2024/0561

Variation of condition 2 of application 2024/0052 (Conversion of detached barn to dwelling including extension) to allow variation to proposed external materials

The Granary, Barnsley Road, Silkstone, Barnsley, S75 4NG

**PROPOSED PLANS AND ELEVATIONS AT 1:100
 SHOWING EXTERNAL NATURAL STONE CLADDING**

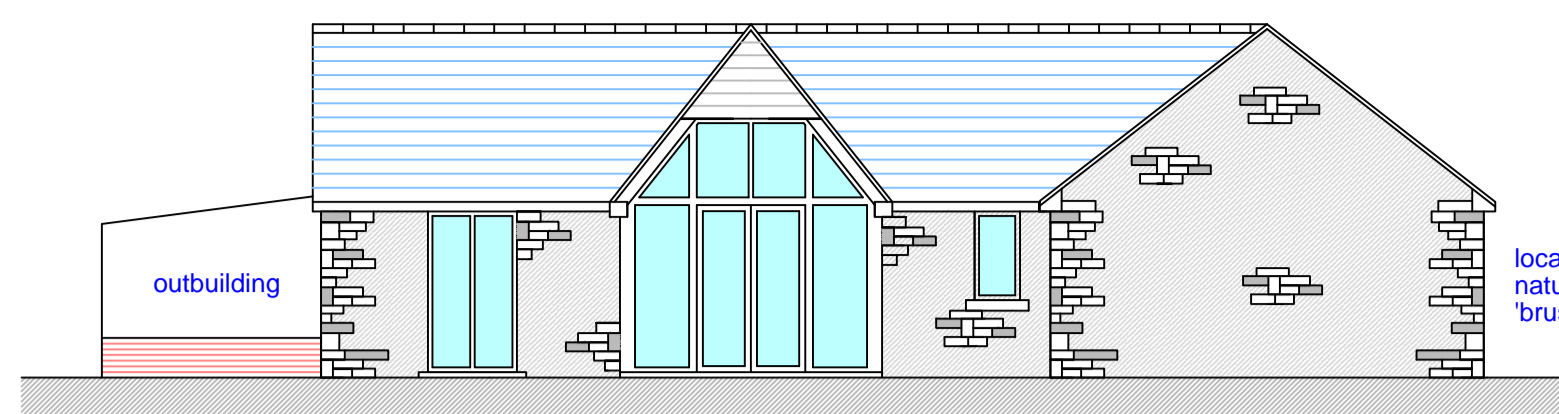
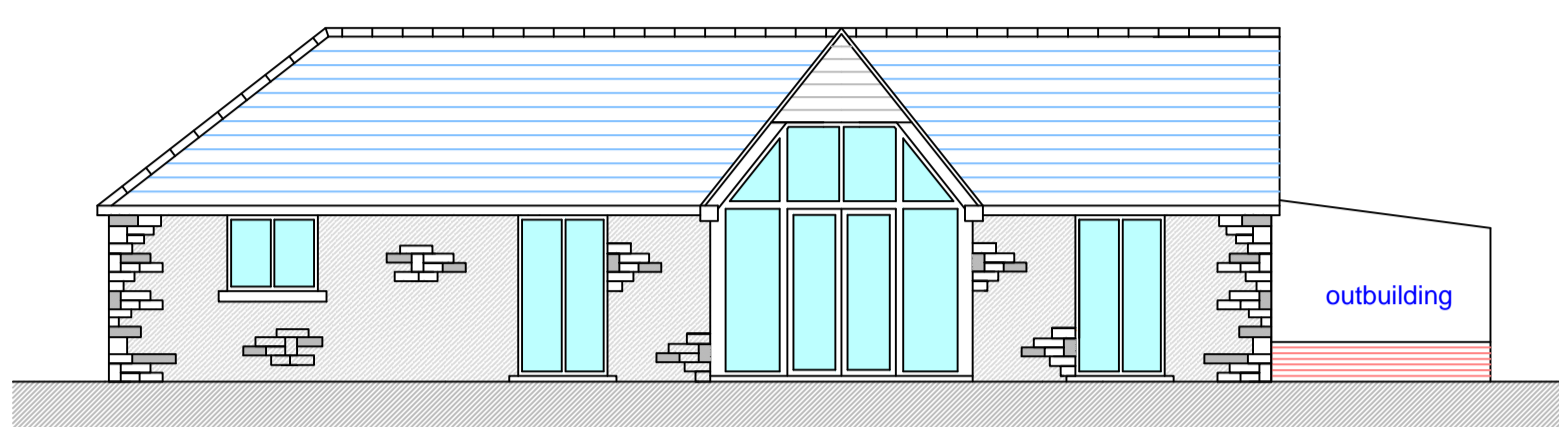
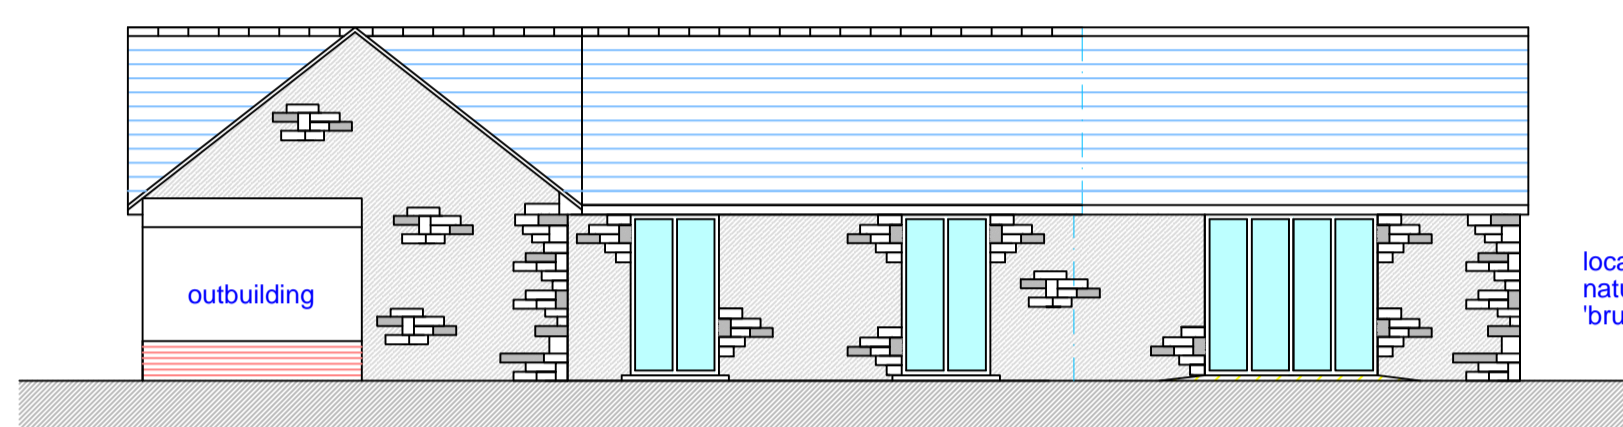
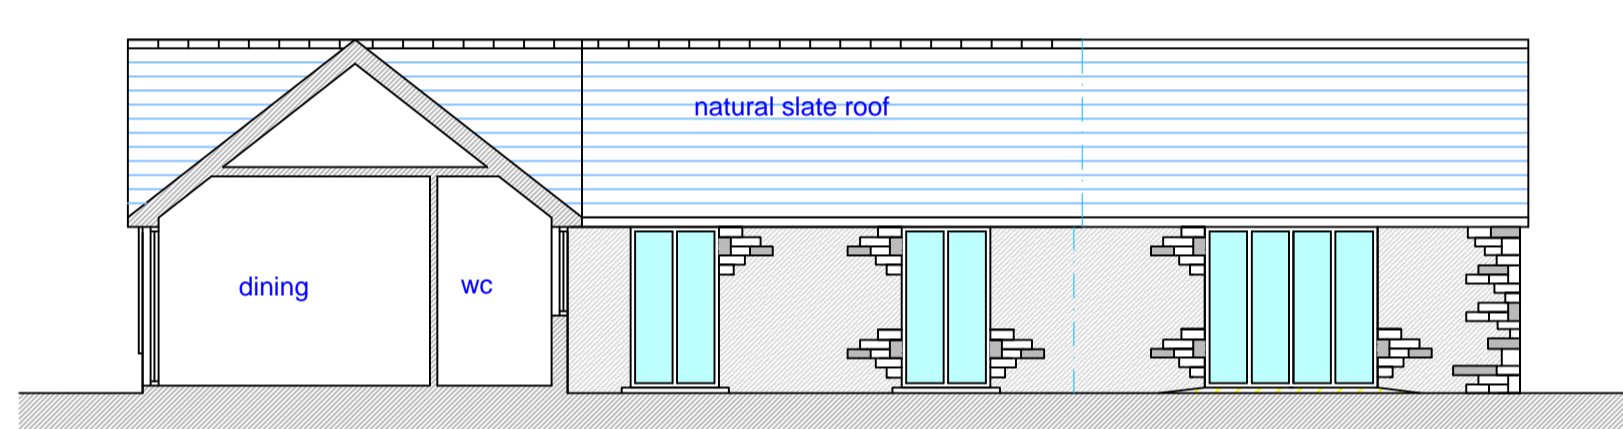
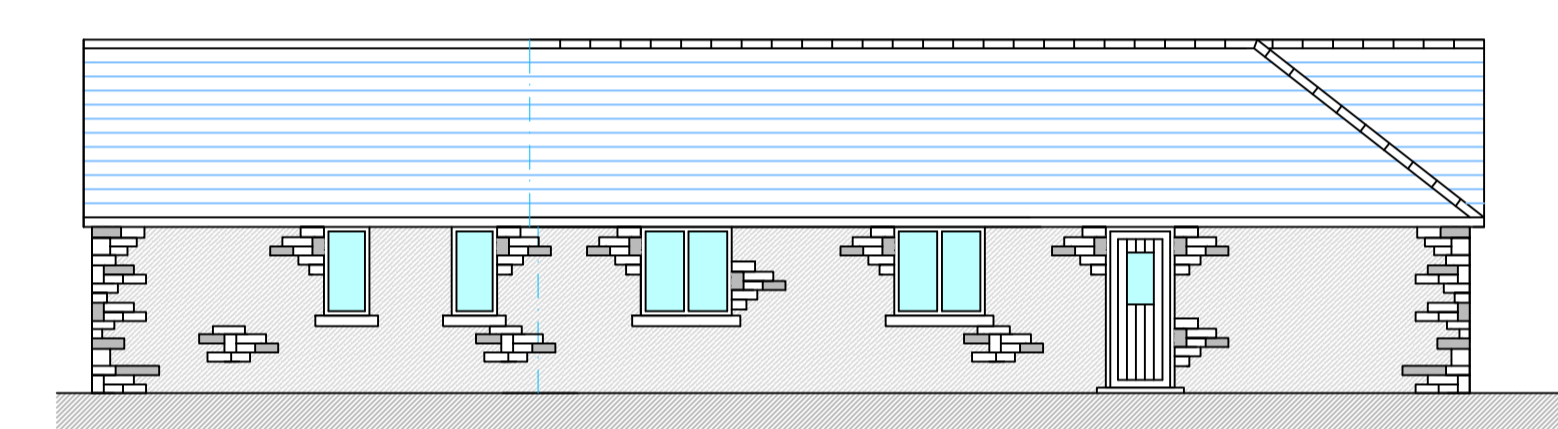
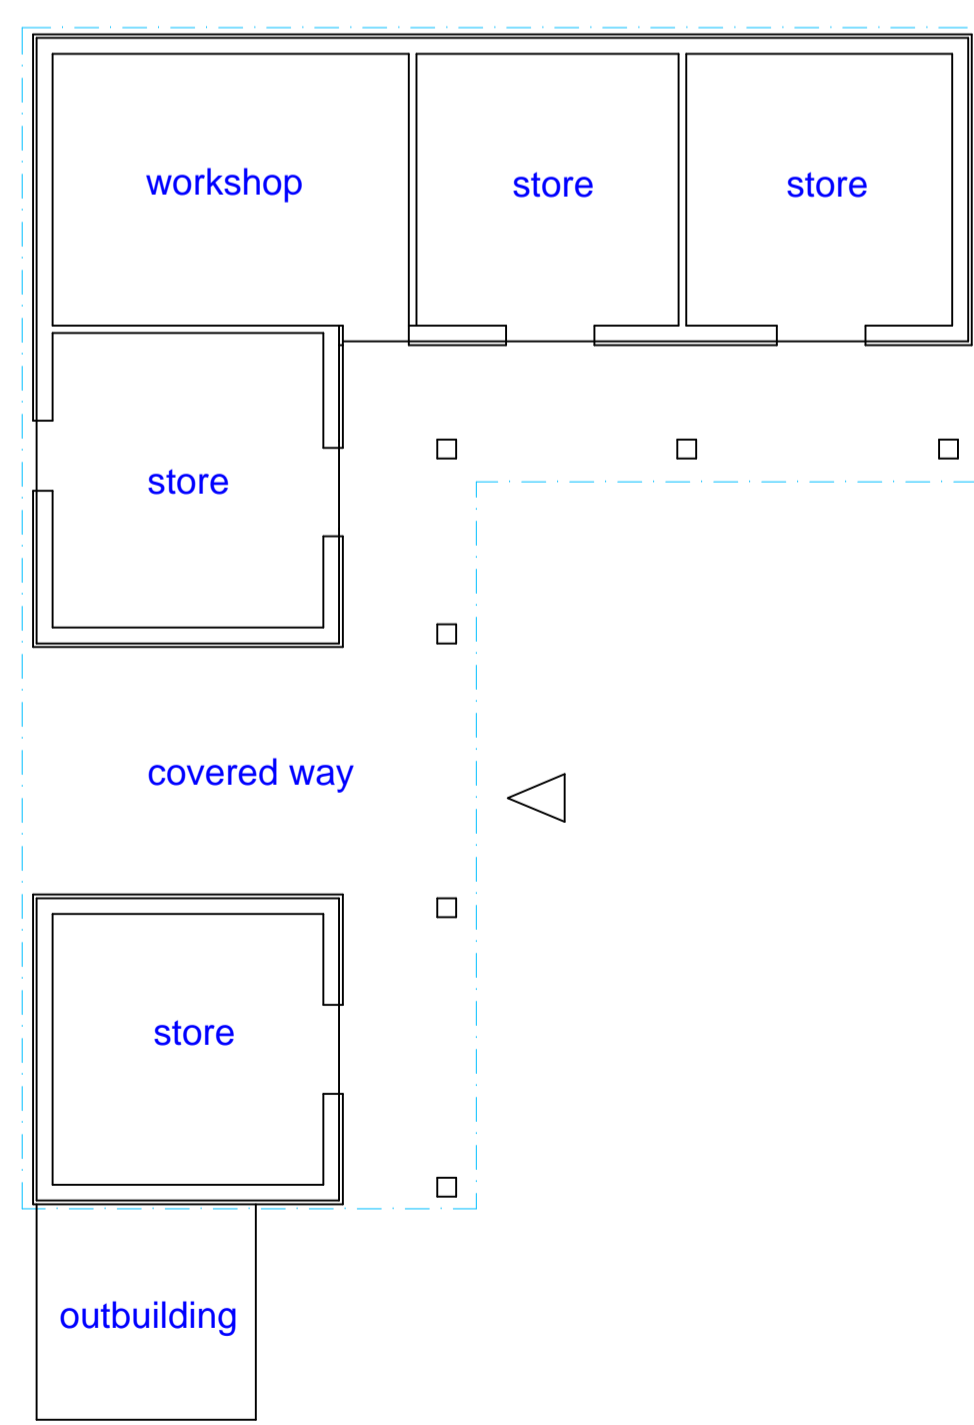
The applicant wishes to change the external walling materials from timber cladding to stone and has provided the following justification:

‘all the external timber boarding would have to be removed to allow for upgrading the wall insulation. Introducing regular coursed local stone would help improve the overall thermal quality of the building envelope.’ A plan has been submitted demonstrating the walls which will require rebuilding as part of the conversion which are as agreed.

The Conservation Officer has been consulted due to the request to change the materials proposed. The Conservation Officer states that: ‘I see little harm in changing the horizontal cladding to stone given this is likely to harmonise with the setting better and be more typical of materials in the vicinity. I still feel the setting is likely to remain largely unchanged, and in fact the use of stone is something that was discussed in the original conversion with the Architect.’

The change in materials is therefore acceptable from a conservation and visual amenity perspective in accordance with policy D1, HE1 and HE3 of the Local Plan.
